The Drovers Solar Farm

Statement of Common Ground (SoCG) with Borough Council of King's Lynn and West Norfolk (Clean)

PINS reference: EN0110013

Document reference: APP/5.20.1 (Revision 1)

The Drove, Swaffham Solar DCO	PROJECT
Ground Nesting Bird Strategy	TITLE
6806/GNBS2	DRAWING NO.
A/DO	REV
September 2025	DATE
LP/DO	QC

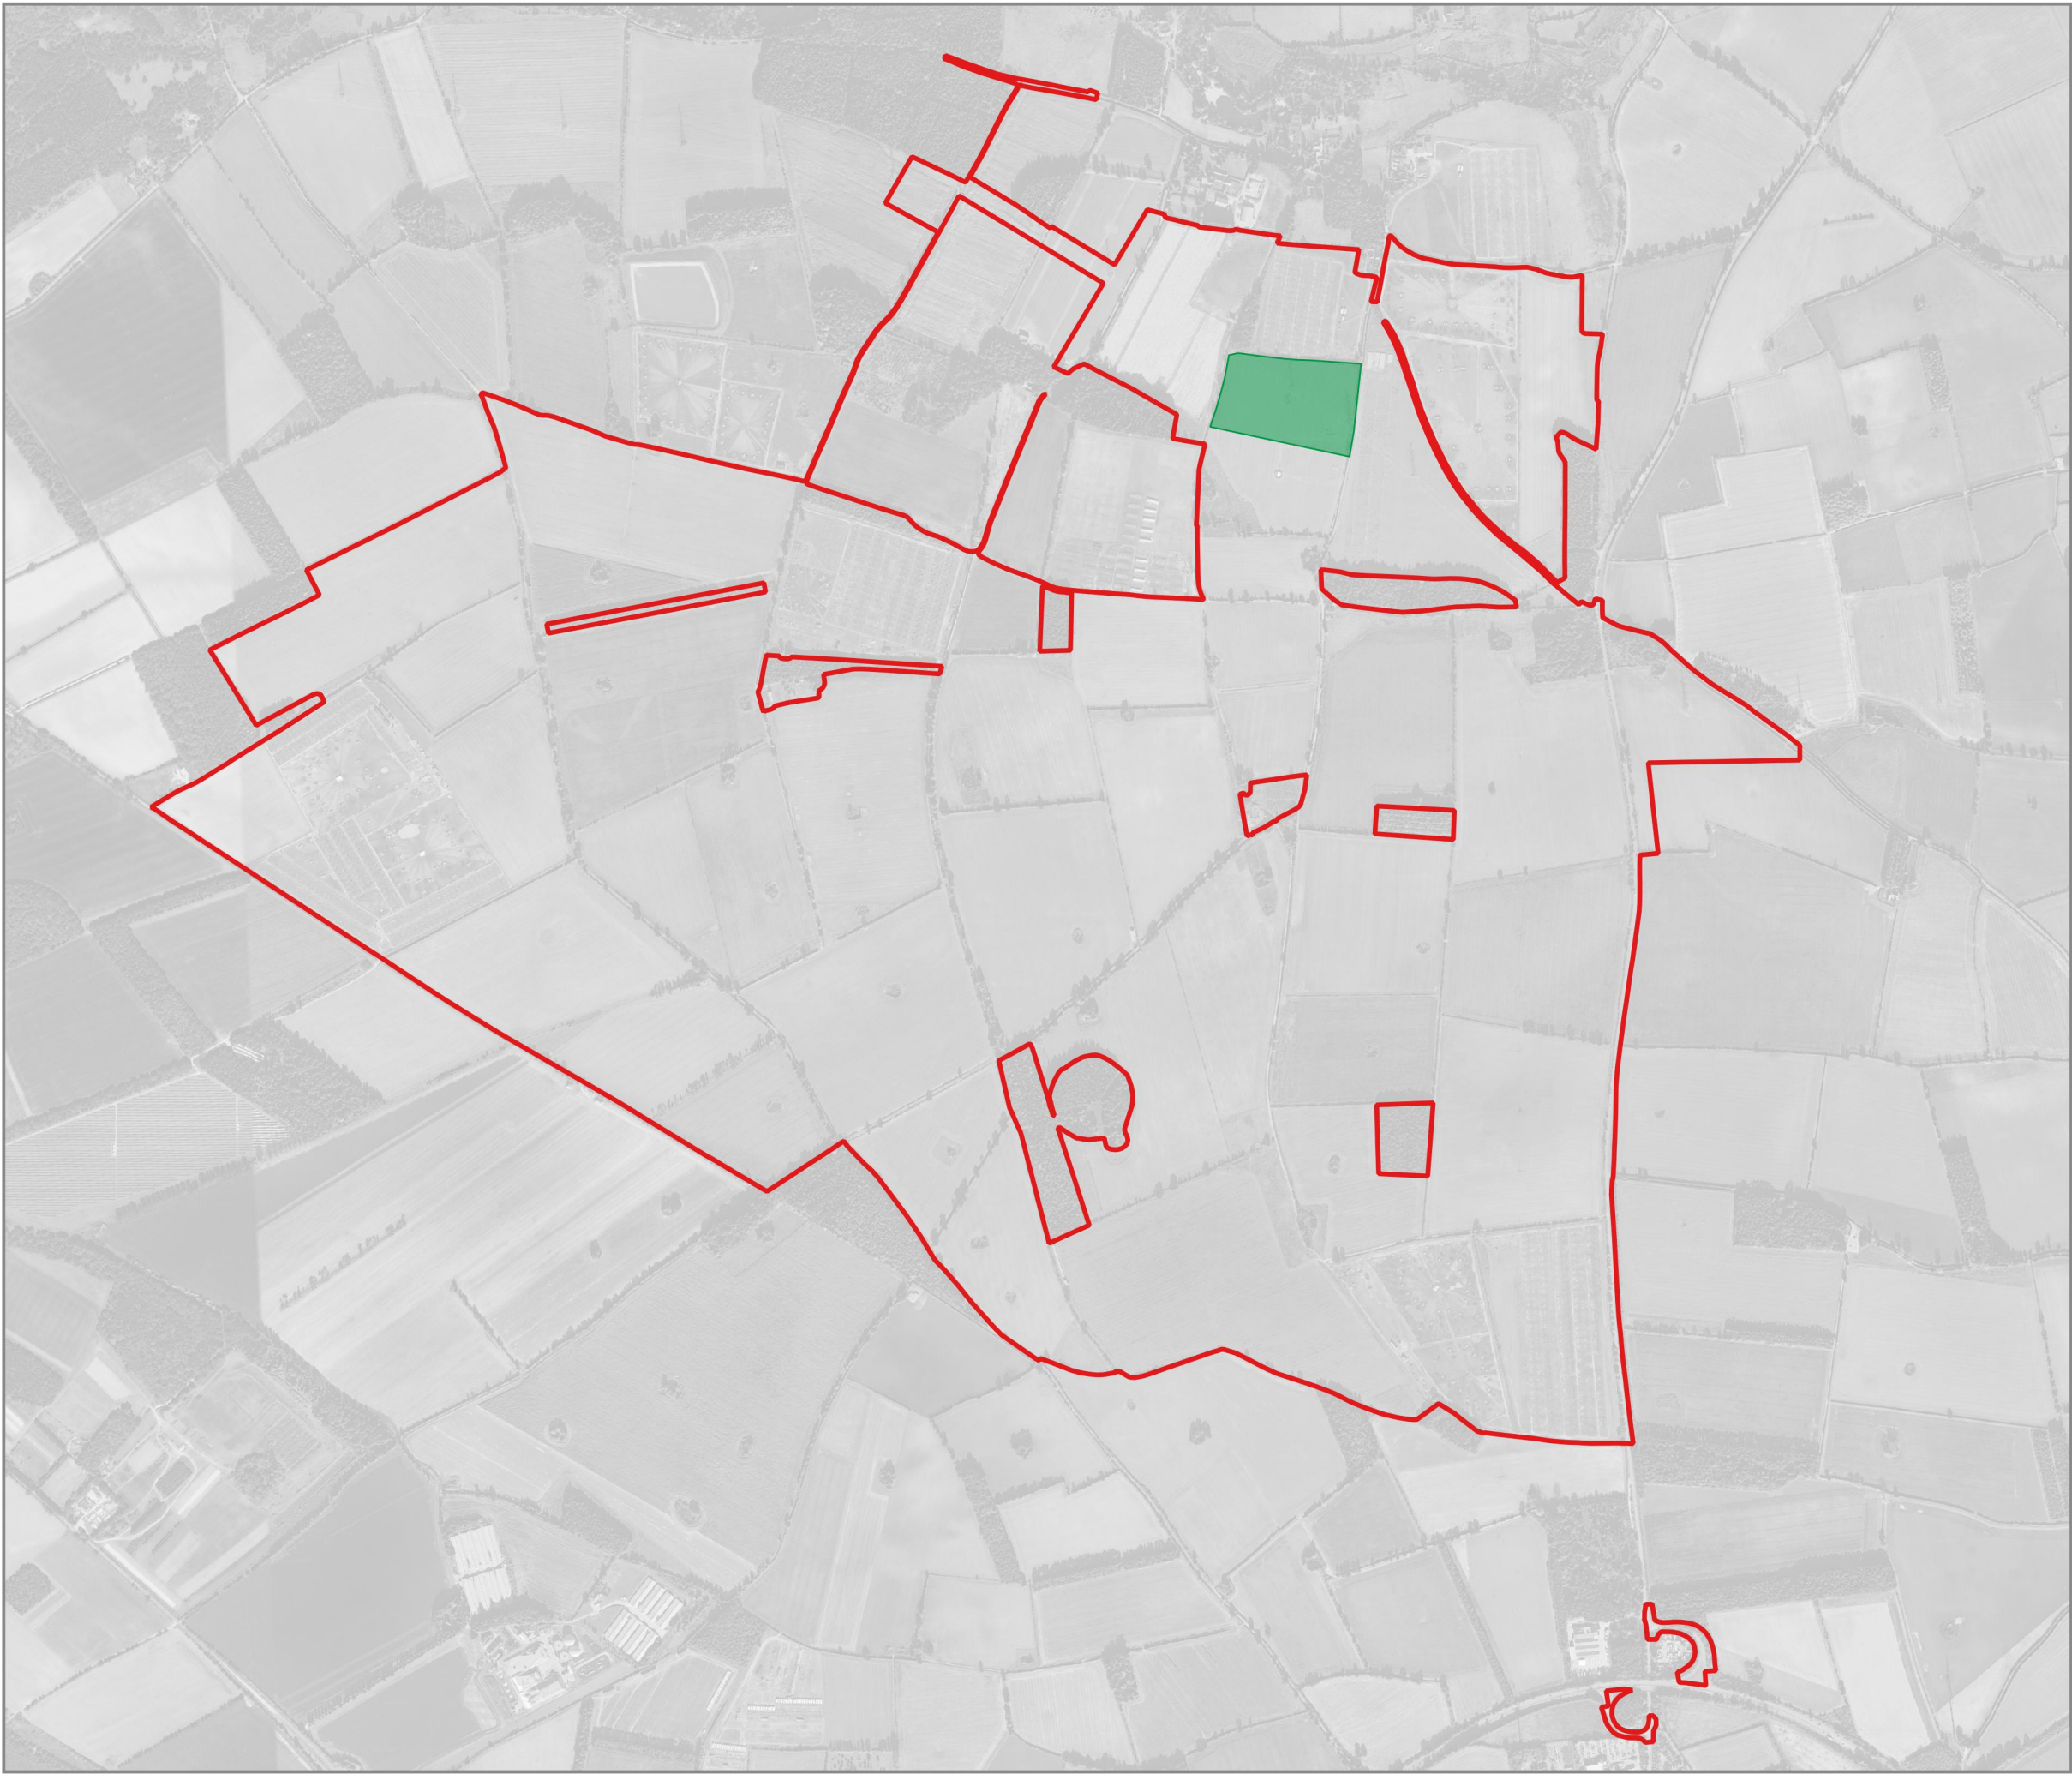
decommissioning, as well as measures to prevent lighting impacts.	that the associated areas used by raised numbers of bats remain unlit, subject to which the location of the BESS and substation within the internal areas of Fields 24 and 27 will not be adversely affected. Nonetheless, further clarification in regard to important features and corridors through the Site can be worked up in order to further progress discussions with the Council and other consultees with a view to overcoming the concerns raised.	
KLWN 3-3	Badgers	On the basis of fencing retaining key wildlife corridors in the field margins, no significant adverse impact has been identified on badgers.	This is noted by the Applicant	Agreed
KLWN 3-4	Wintering Birds	The magnitude of impact on wintering bird populations would be negligible.	This is noted by the Applicant	Agreed
KLWN 3-5	Skylark Mitigation	The Council raise concerns regarding the methodology behind the plots provided for skylark mitigation at points 3.3.7 and 3.3.8 of the Local Impact Report [REP1-079]	As set out within the ES Appendix 7.3: Proposed Mitigation Strategy for Ground Nesting Birds Requiring Open Habitats [APP-149] , the methodology used in relation to calculation of Skylark mitigation follows the approach set out within published methodology (Fox, 2022). As set out, the initial input figure of 117 pairs has been used in relation to the development footprint (i.e. excludes the 4 pairs within field 32 which is outside of the Scheme's boundary but includes the existing pairs within Fields 33 and 35 and as such these are taken into account). In relation to territories that could be absorbed within 75m of the development edge habitats, in line with the published methodology this relates to an increase in capacity over the existing use due to increased foraging habitat in proximity to the edges of the development and accordingly, the exclusion of the existing pairs within	Under Discussion

Field 32 from the calculations is no different from that within surrounding fields elsewhere, which would be anticipated to support a baseline of Skylark usage, and therefore consistent with the published methodology.	
KLWN 3-6	Impact on Protected Sites	Subject to compliance with the outline Construction Traffic Management Plan and outline Construction Environmental Management Plan, the Council raises no objection in regard to impacts on Protected Sites.	This is noted by the Applicant	Agreed
KLWN 3-7	Request for Habitat Monitoring and Management Plan	The Council request for a Habitat Monitoring and Management Plan to be secured through the DCO, notwithstanding the outline LEMP already submitted.	This is noted and agreed by the Applicant	Agreed

Figure 6.15: PM8, PM12 and PM14 Summer Photomontages - Illustrative Scheme (Part B) (Clean)

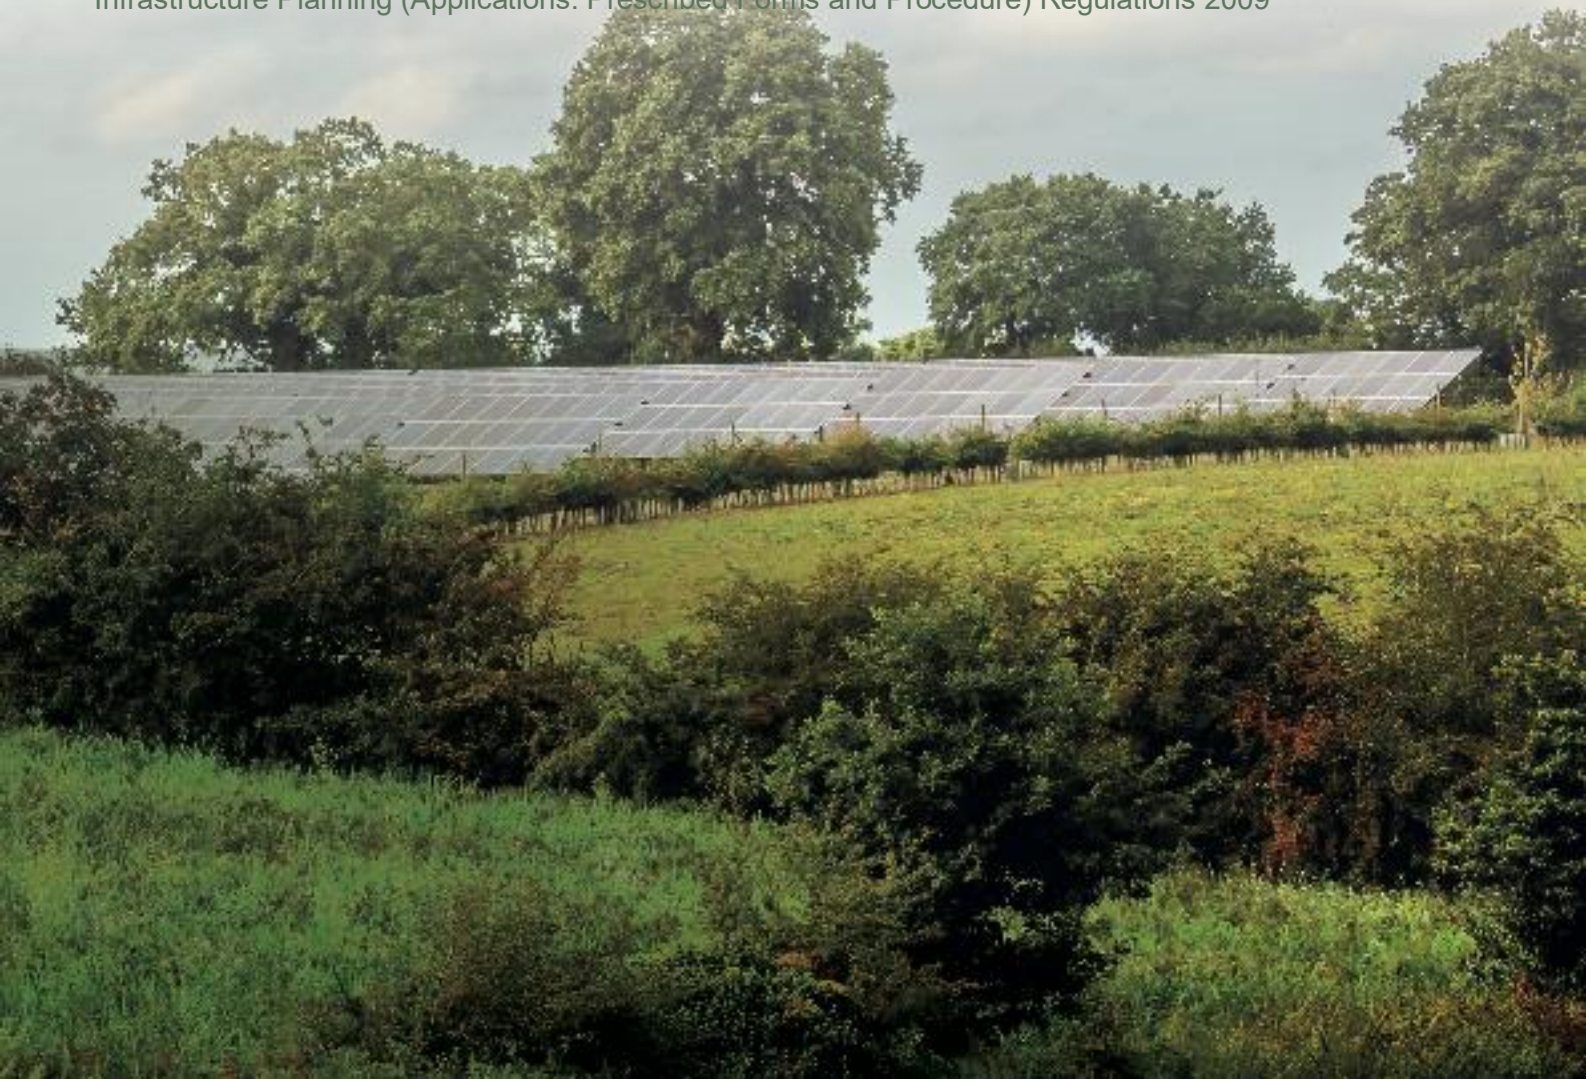
KLWN 1-2	Key Views	The Applicant has worked with the Borough Council's planning and heritage teams to reduce harm as much as possible. Moving the substations out of direct view from Castle Acre and placing them south of Bartholomew's Hill Plantation would not eliminate harm but would filter views and lessen visual impact. Removing solar PV from the northern part of field 33 is also positive, as the topography means the remaining panels would sit beyond the crest and be barely visible.	There is no anticipated substantial harm to, or total loss of, any designated heritage assets' significance as a result of the Scheme. ES Chapter 8: Cultural Heritage and Archaeology [APP-057] outlines that 'substantial harm' is afforded to any adverse effect that is of a major magnitude, whilst moderate, minor or negligible adverse effects represent effects that are of 'less than substantial harm' in nature. As detailed in the submitted visualisations (ES Figure 6.14: PM8, PM12 and PM14 Winter Photomontages - Illustrative Scheme [AS-039] and ES Figure 6.15: PM8, PM12 and PM14 Summer Photomontages - Illustrative Scheme [AS-045]), the National Grid	Medium

Substation and the Customer Substation will be entirely screened by Bartholemew's Plantation in views from the north, thereby removing, rather than reducing, visual impact. As described in ES Chapter 8: Cultural Heritage and Archaeology [APP-057] , new pylons will be visible, but not other elements of the National Grid Substation and the Customer Substation.	
KLWN 1-3	Level of harm outlined within ES Chapter 8	The Council disagree with the assessment and level of harm that has been attributed to the development within ES Chapter 8: Cultural Heritage and Archaeology. The Council maintain that as an integral part of the significance of the Castle and Conservation Area at Castle Acre, this change in land use would result in less than substantial harm, moderate in scale, to the significance of the castle at castle acre and a moderate level of less than substantial harm to the setting of Castle Acre Conservation Area.	In terms of the scales of impact as defined in ES Chapter 8: Cultural Heritage and Archaeology [APP-057] in order to be a moderate impact there would need to be considerable harm to a heritage asset's setting, such that the asset's significance would be materially affected/considerably devalued, but not totally or substantially lost. This is a relatively high level of impact which is not reflected by the Scheme, which would retain the village siting, the visual and spatial connection between the assets, the connection to the Peddars Way and the vast majority of the surrounding landscape visible from the heritage assets. The majority of views will be unchanged, with only very small elements of the wider Scheme remaining. Whilst the overall Scheme is large in scale the aspects of the settings of the designated heritage assets that will be subject to change have been minimised through embedded mitigation measures. The Applicant is satisfied that the levels of harm identified within ES Chapter 8: Cultural Heritage and Archaeology [APP-057] (Scenario A – Minor, Scenario B - Neutral) are robust and justifiable.

Insert 1: New Predictive ALC Map with Site Edged Red

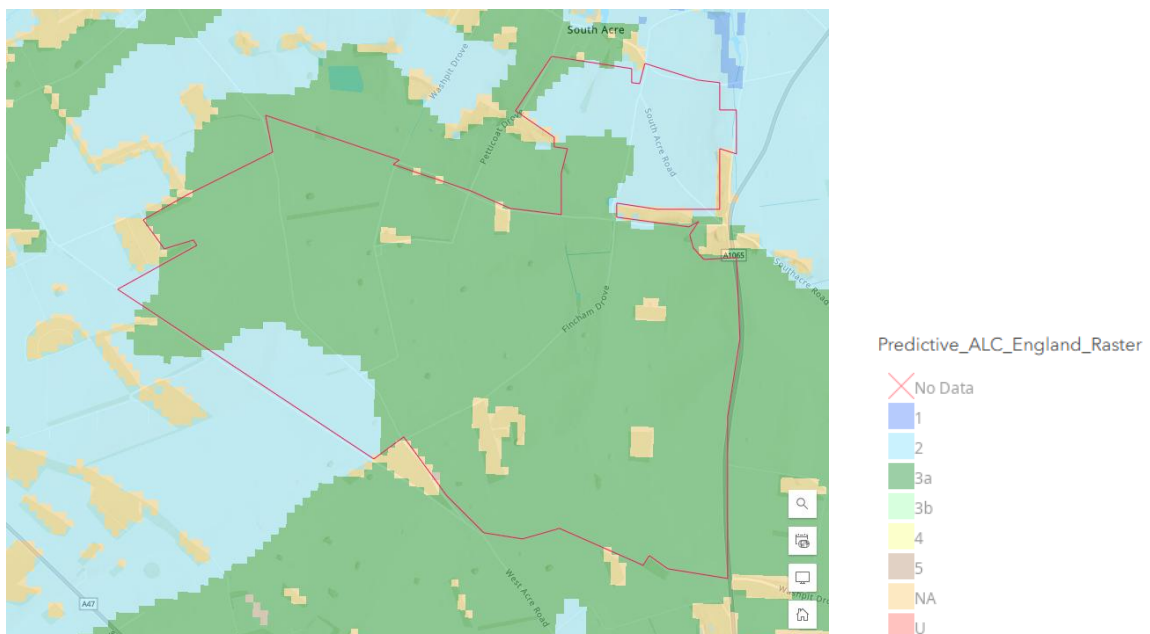
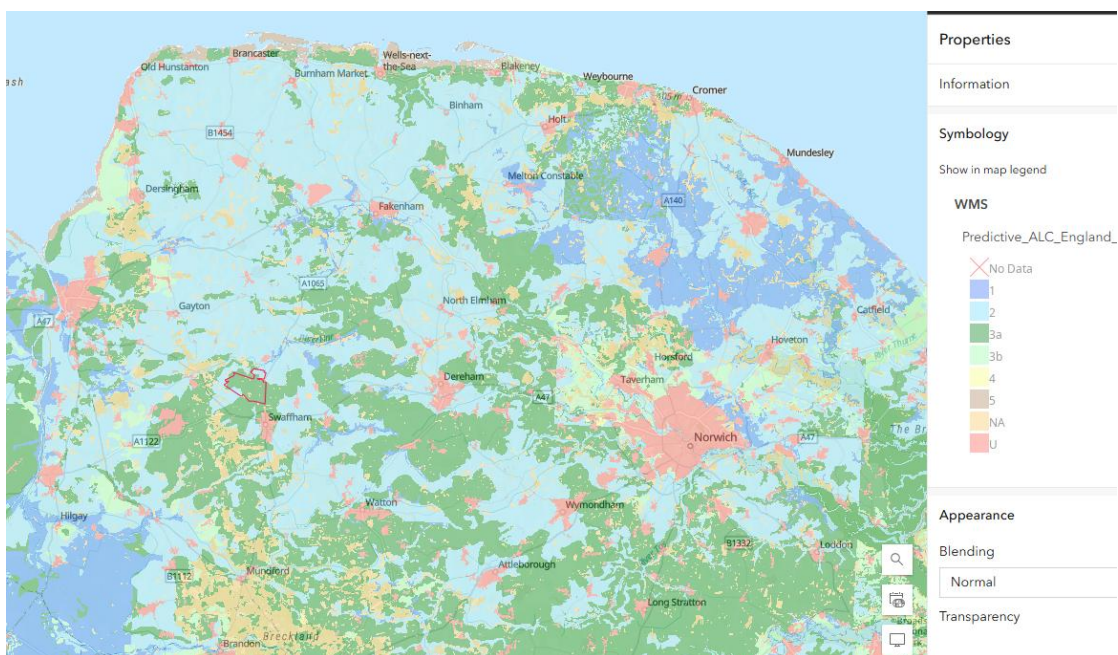
Reference	Topic	Consultee's Position	Applicant's Position	Status
KLWN 4-1	BMV Land	This Scheme would result in approximately 55% of the site falling within the definition of Best and Most Versatile (BMV) agricultural land. Whilst the 60 year decommissioning timeframe set out by Requirement 20 is noted,	The effects on land of BMV quality, and the small areas adversely affected, are set out in ES Chapter 11: Soils and Agriculture [AS-018] . There is no policy that requires agricultural land of BMV or non-BMV quality to be farmed, and the implications for food production and the local land-based economy are set out in ES Chapter 11: Soils and Agriculture [AS-018] sections 11.8 and 11.11. ES Chapter 11: Soils and Agriculture [AS-018] concludes that, with embedded and additional mitigation	High

the loss of BMV, particularly in combination with other schemes across Norfolk as a whole is a concern for the Borough Council.	measures in place, the Scheme itself would not result in any significant adverse effects on soil or agricultural land resources throughout its lifecycle. There will be some permanent land take associated with the National Grid Substation and Grid Connection Infrastructure, but this only amounts to less than 5 ha of BMV land. A worst-case assessment is also set out should the BESS and Customer substation not be restored. The loss in that case would exceed 20 ha, but even with woodland planting it would amount to 27ha of BMV (11.8.52). In terms of cumulative effects, four NSIP schemes were identified near the Scheme, two of which were for solar development, and these are assessed in Chapter 11 and listed in Table 11-10. At the time of the ES, limited information about the ALC grading was known, but in respect of land loss (as distinct from land use) the adverse effects were considered to be limited. Cumulatively, however, there is the potential for the loss of more than 20ha of BMV as a result of these schemes and as reported in paragraph 11.11.15 the cumulative effect is therefore recorded as significant. An Applicant's Update Note on Published Information and Cumulative Assessment on Agricultural Land Quality [REP1-072] provides information about the new Predictive Agricultural Land Classification Map for England (Defra, April 2026) and also assesses a wide range of other developments across Norfolk. This information will be updated further and incorporated into a revised ES Chapter 11: Soils and Agriculture [AS-018] as soon as practicable.
